Addendum No. 1

RE: Contract ID C203207

Rowan County (P-5206B, P-5206C, P-5206D)

NCRR/NSR Mainline Reid To North Kannapolis Railroad Roadbed (MP 337 To MP 348.3)

PROJ. REFERENCE NO. P-5206C	SHEET NO. TMP-6
--------------------------------	--------------------

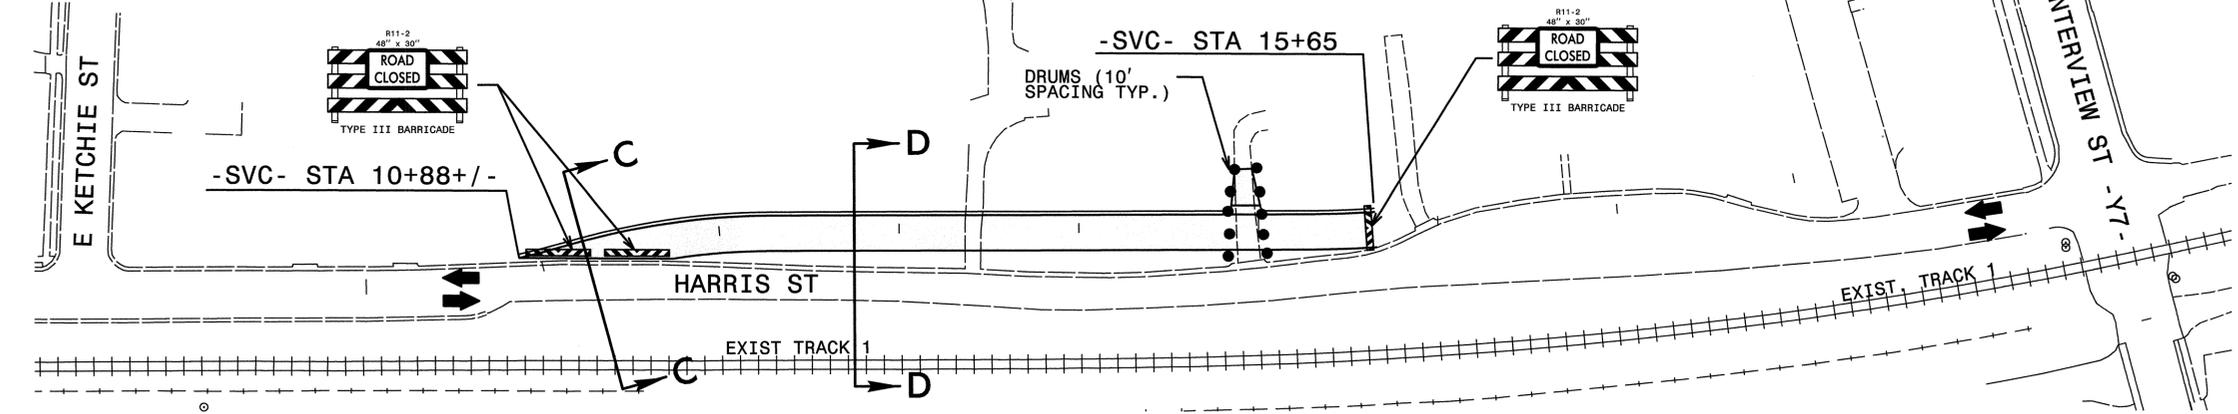
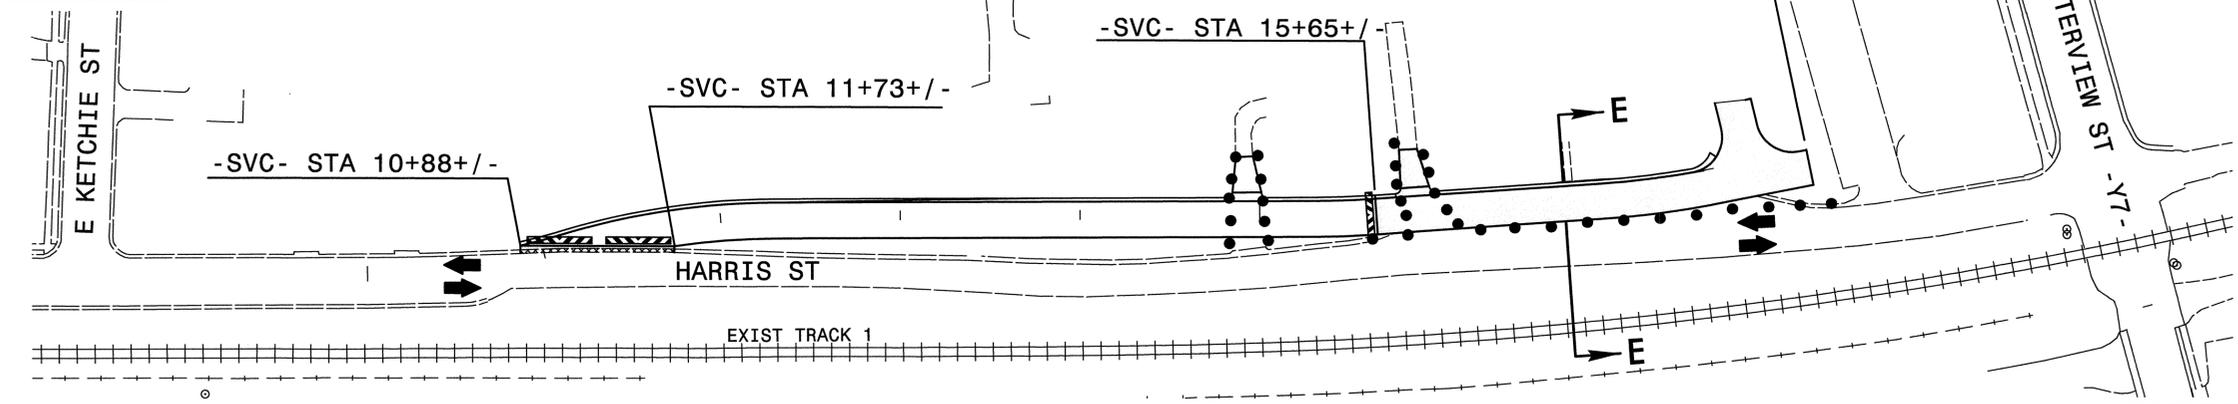
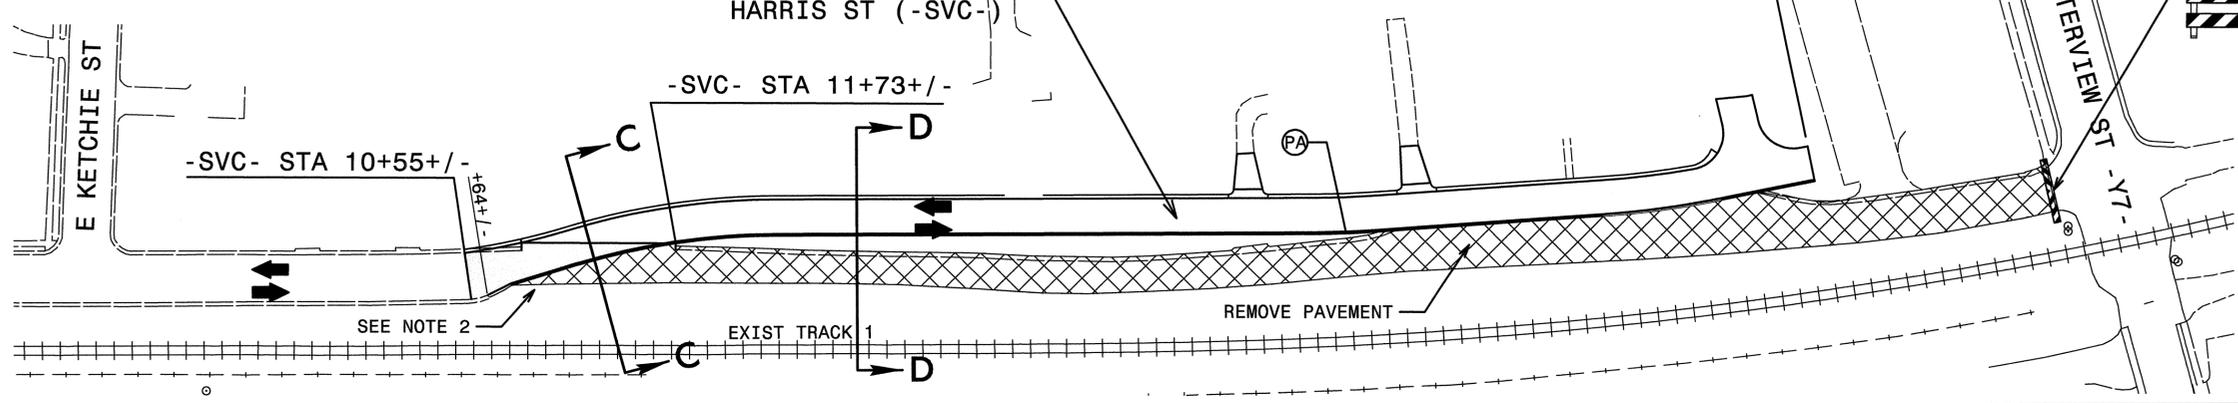
Sheet	Revisions
TMP-2, 5, 8	Revised phasing to construct all approaching roadway up to proposed crossing first to match the ICTs in the Contract.
EC-4, EC-6 thru 12, EC-15 thru 22, EC-24 thru 30, EC-33 thru 39	Revised silt fence and check dam locations to match revised Roadbed and Grading Set.
